Comments for Planning Application 21/01391/HOUSE

Application Number: 21/01391/HOUSE

Address: 7 Kingsingfield Close West Kingsdown KENT TN15 6LP

Proposal: Demolition of existing single storey garage and outbuilding. New single storey rear extension with flat roof and glazed lantern light. New two storey side extension.

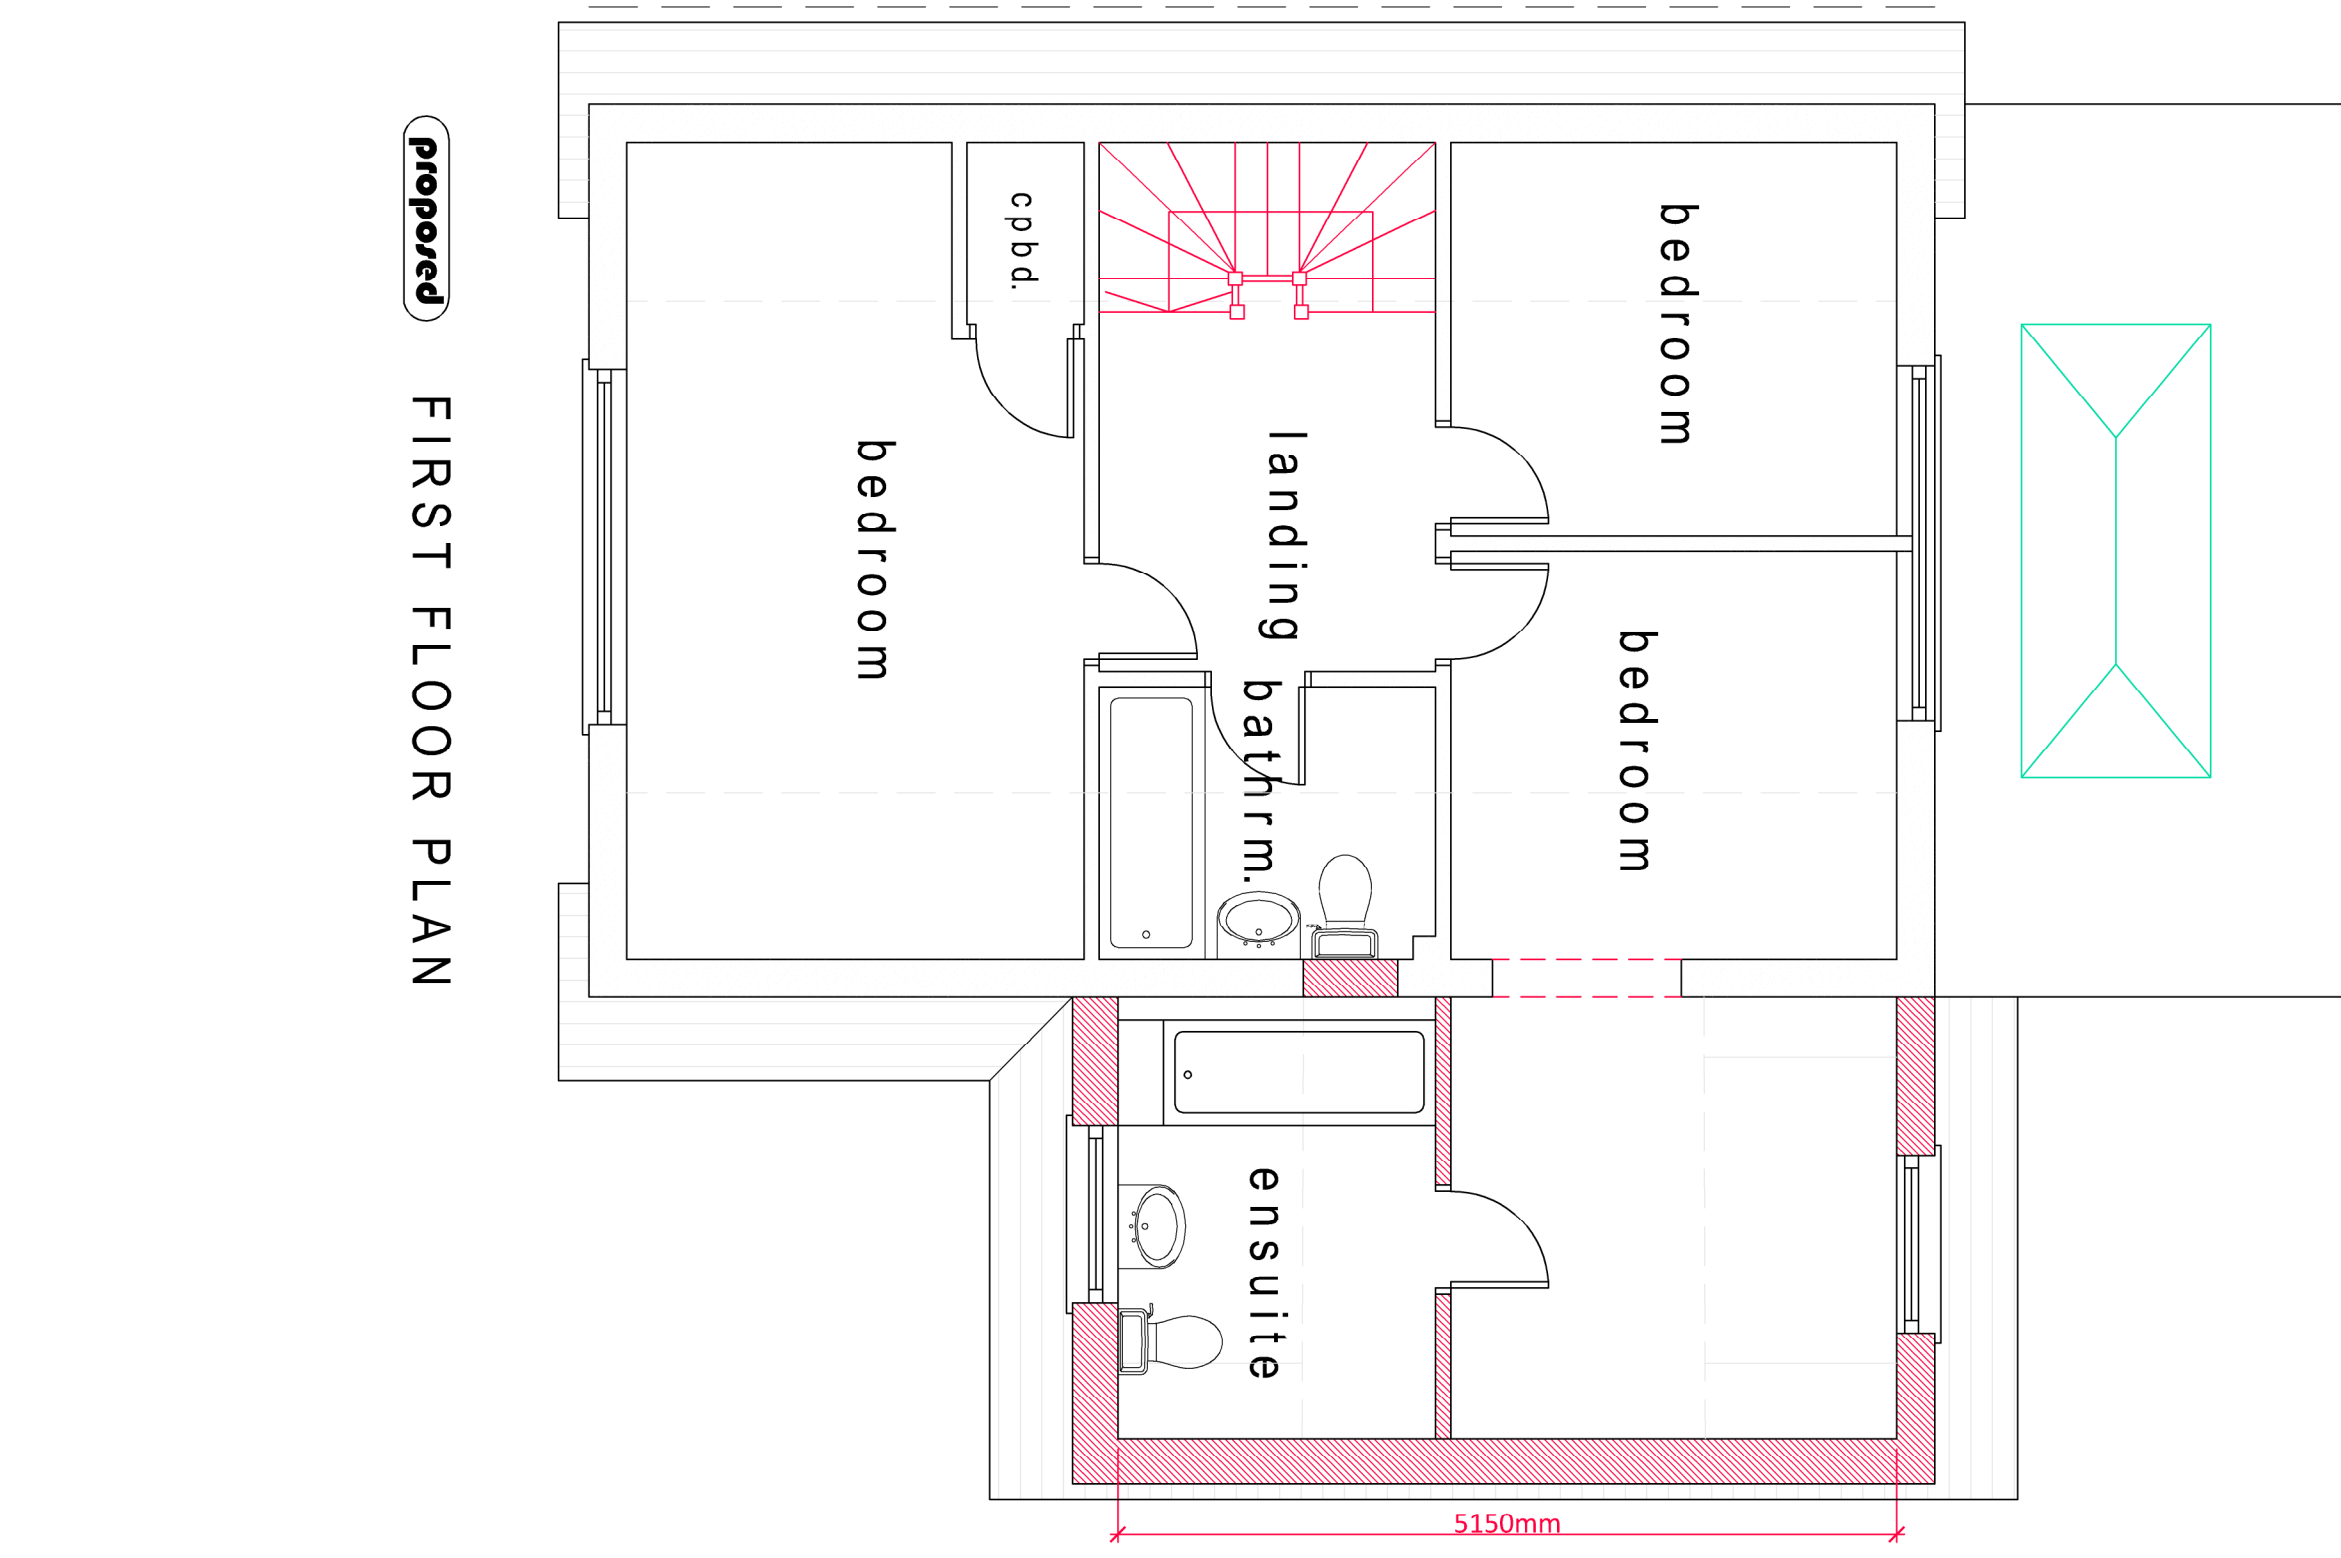
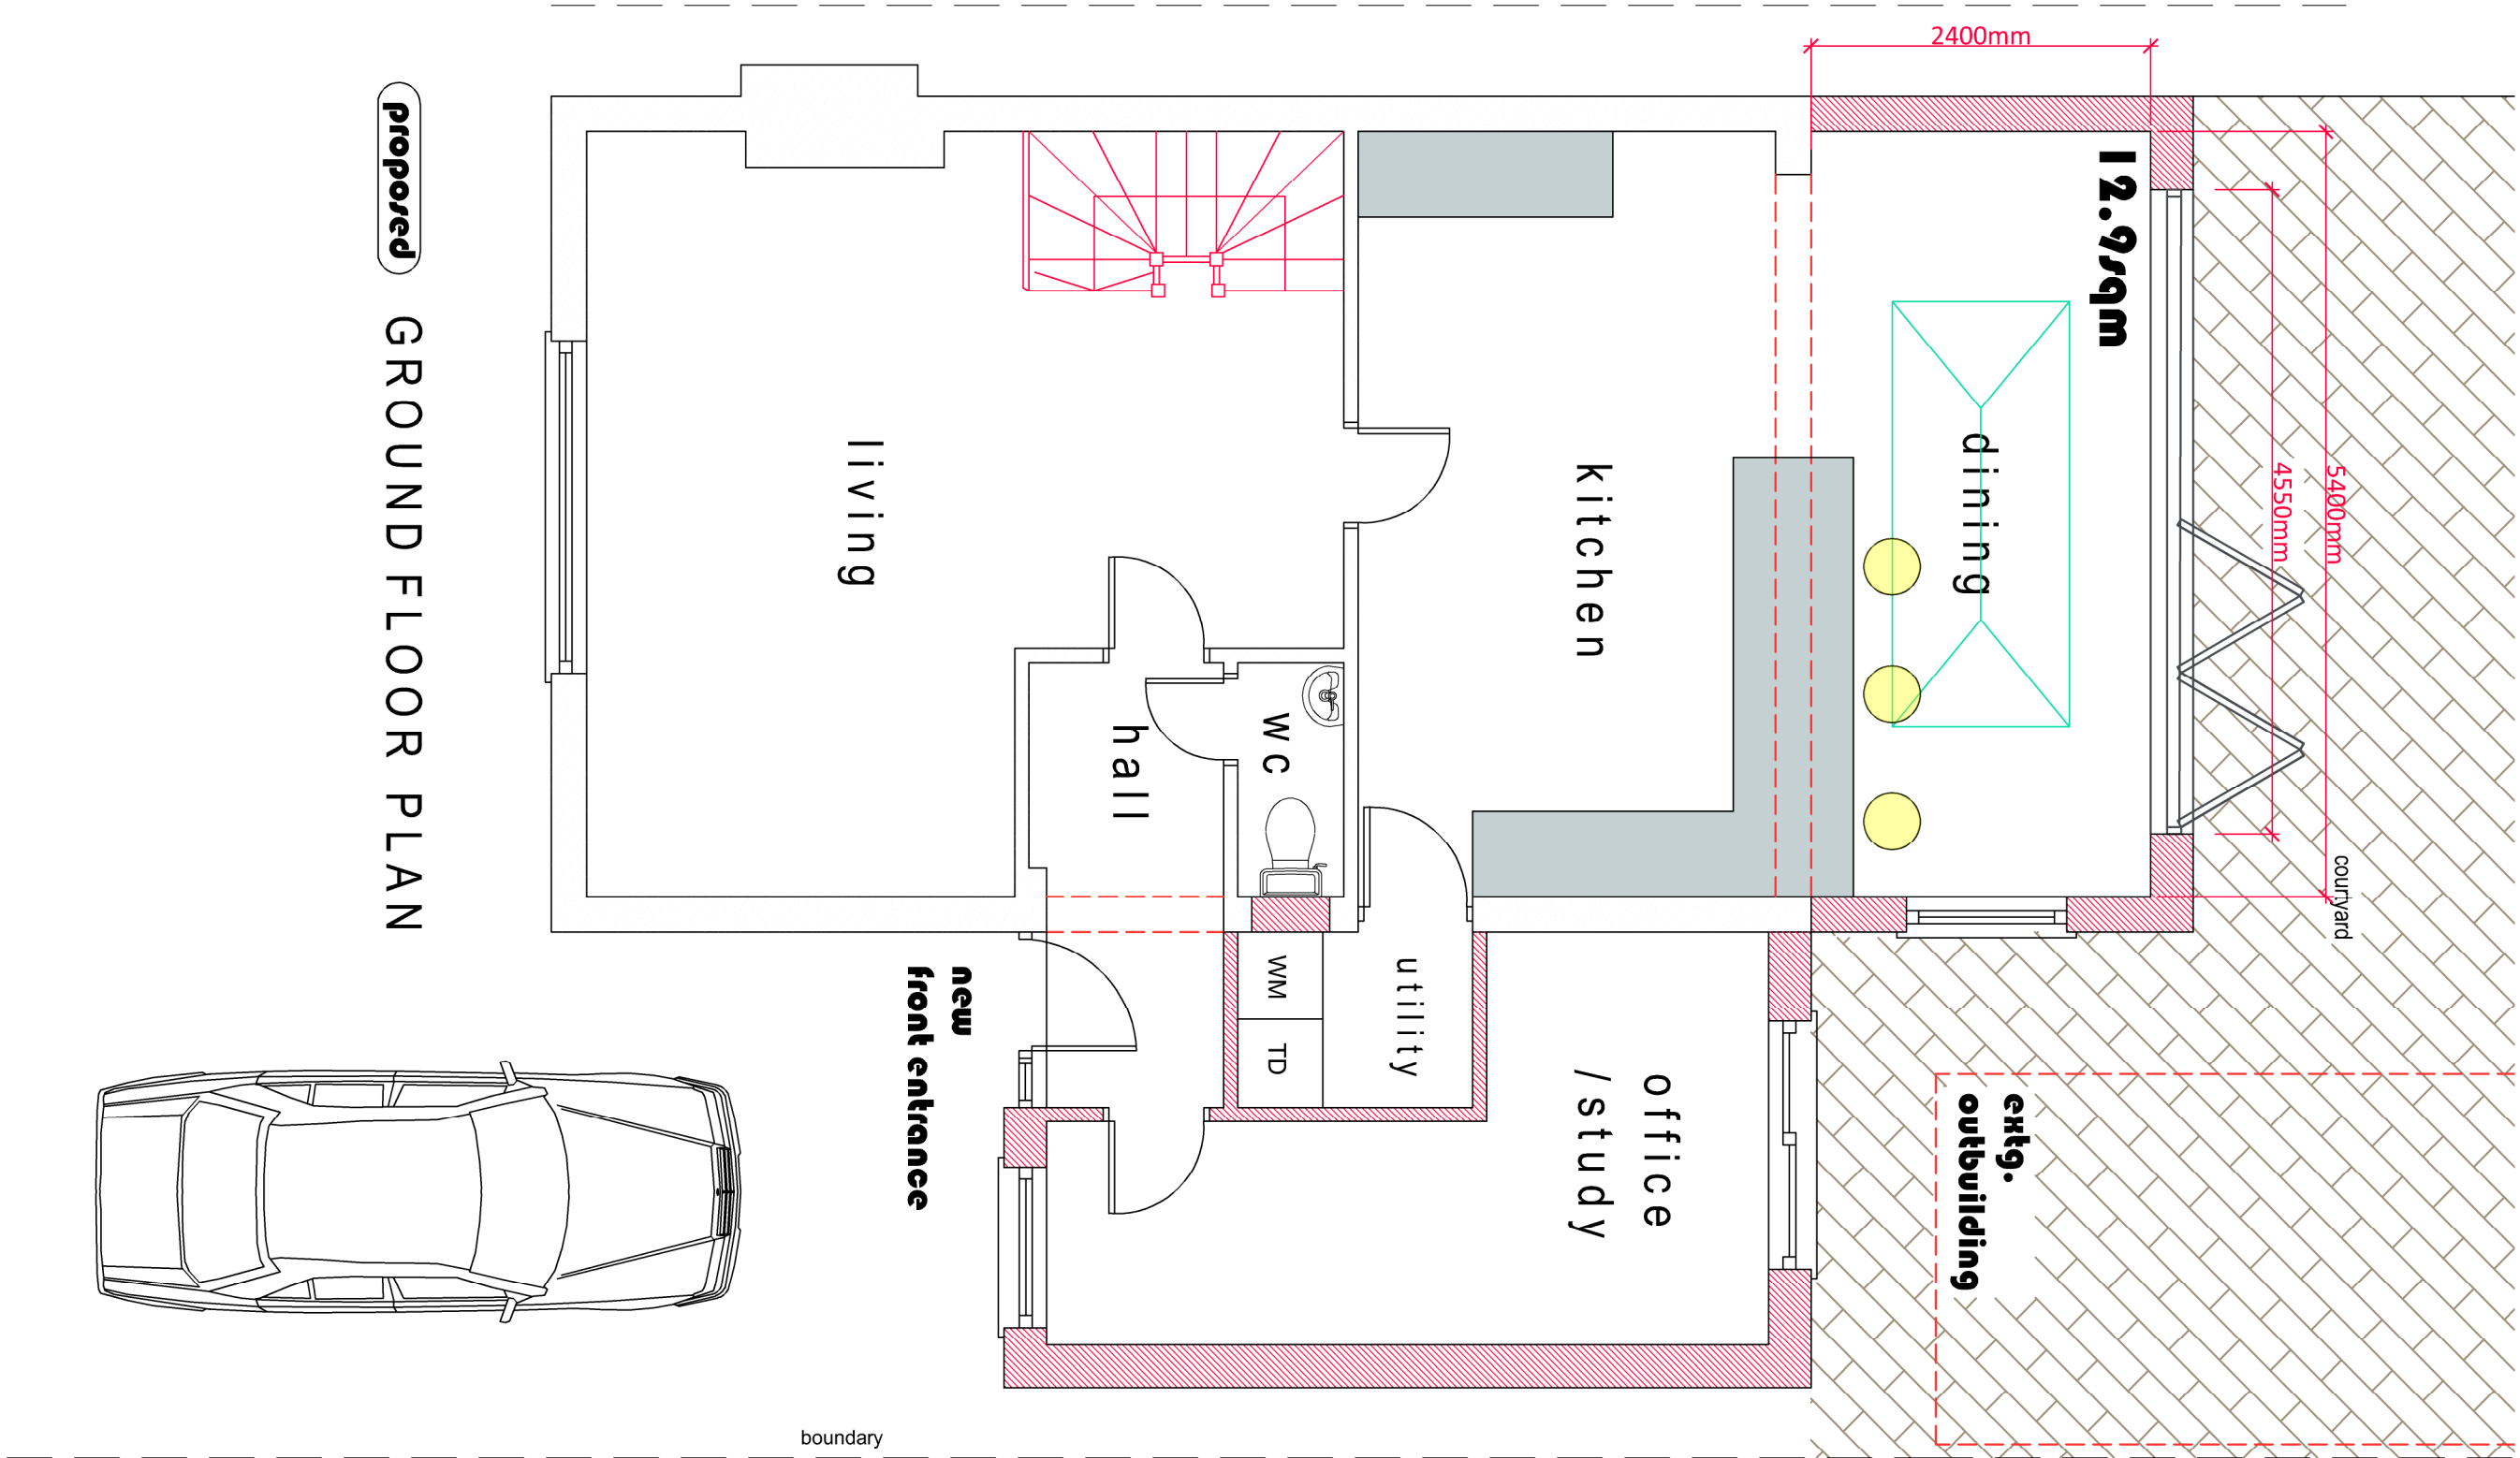
It would not be in keeping with the other 7 identical houses in Kingsingfield Close and would irrevocably change the street scene of the close

The 2 storey extension will overlook our property intruding on our privacy, as they stated they already have a small garden in close proximity to our boundary fence. They already have one first floor window overlooking our property and are now proposing a second one.

The first floor window would impact on our privacy and that of other properties. If permission were granted it would be expected that a condition of a non opening obscured glass window be made.

The two storey extension would give very limited space between numbers 6 and 7 Kingsingfield Close and would block out light and sunlight from the gardens

Parking: This extension would result in there only being one parking space to the front of their property meaning that their second car would have to be parked on the cul-de-sac road causing difficulty for emergency vehicles, refuse collection vehicles and the other residents access and road safety in the close.
